From: Bloomer, David <David.Bloomer@lancashire.gov.uk>
Sent: 09 March 2017 09:26
To: Rebecca Halliwell
Cc: LHS Customer Service; planning
Subject: app3/2017/0138 7 Berry Lane Longridge

PROPOSED ADDITIONAL SIGNAGE  
 AT LONGRIDGE DENTAL SURGERY  
 7, BERRY LANE, LONGRIDGE, PR3 3JA  
 CLIENT: MR. NICHOLAS S. RICHARDSON BDS.  
 DRAWN: JOHN JACKSON. SCALE 1:50

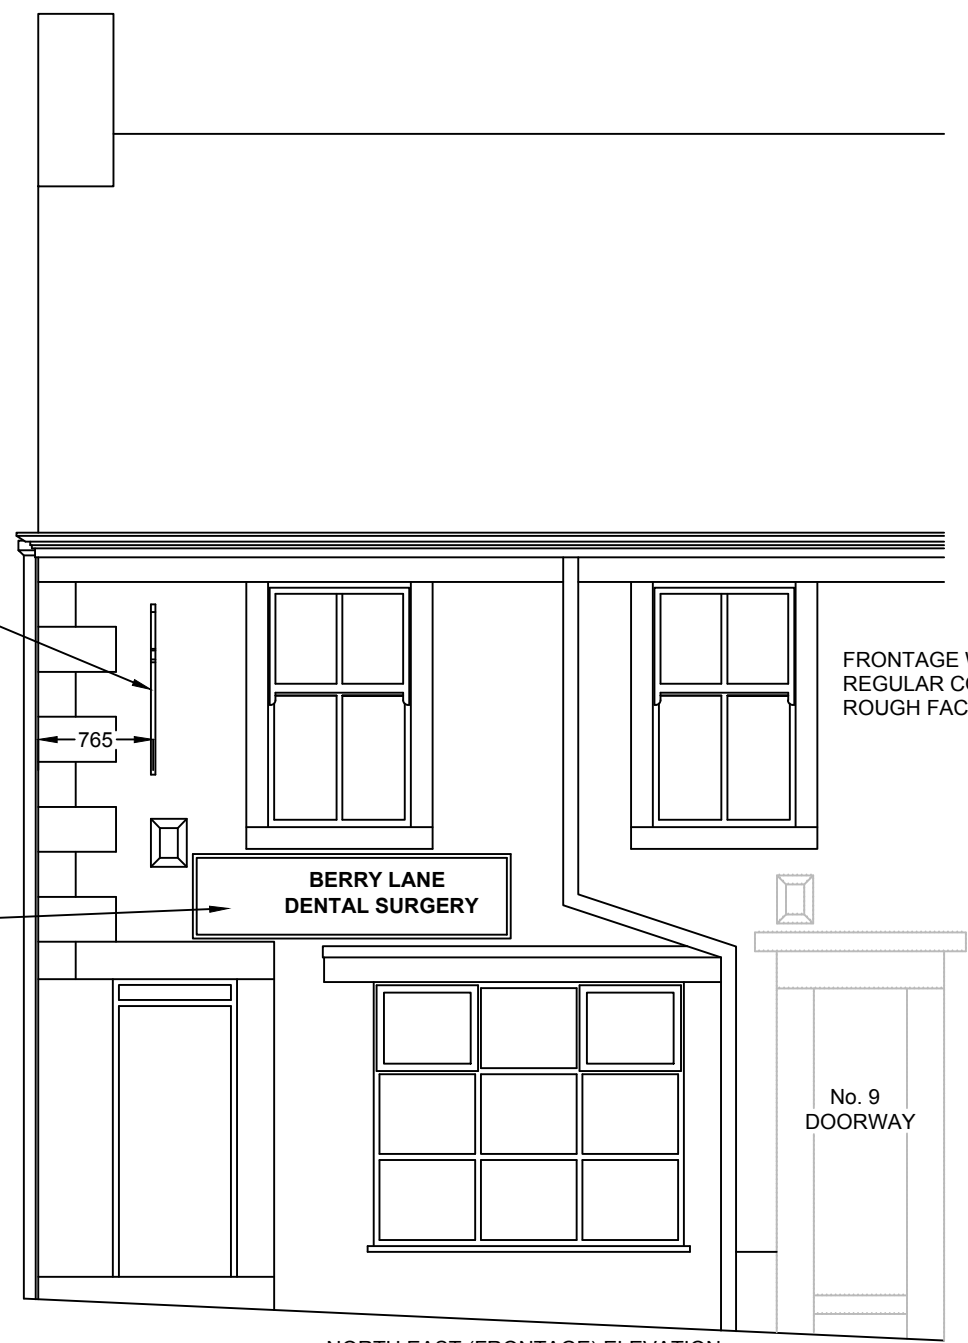
The proposal raises no highway concerns and I would be minded to raise no objection to the proposal on highway grounds but would it be possible to have details of the legend on the sign?
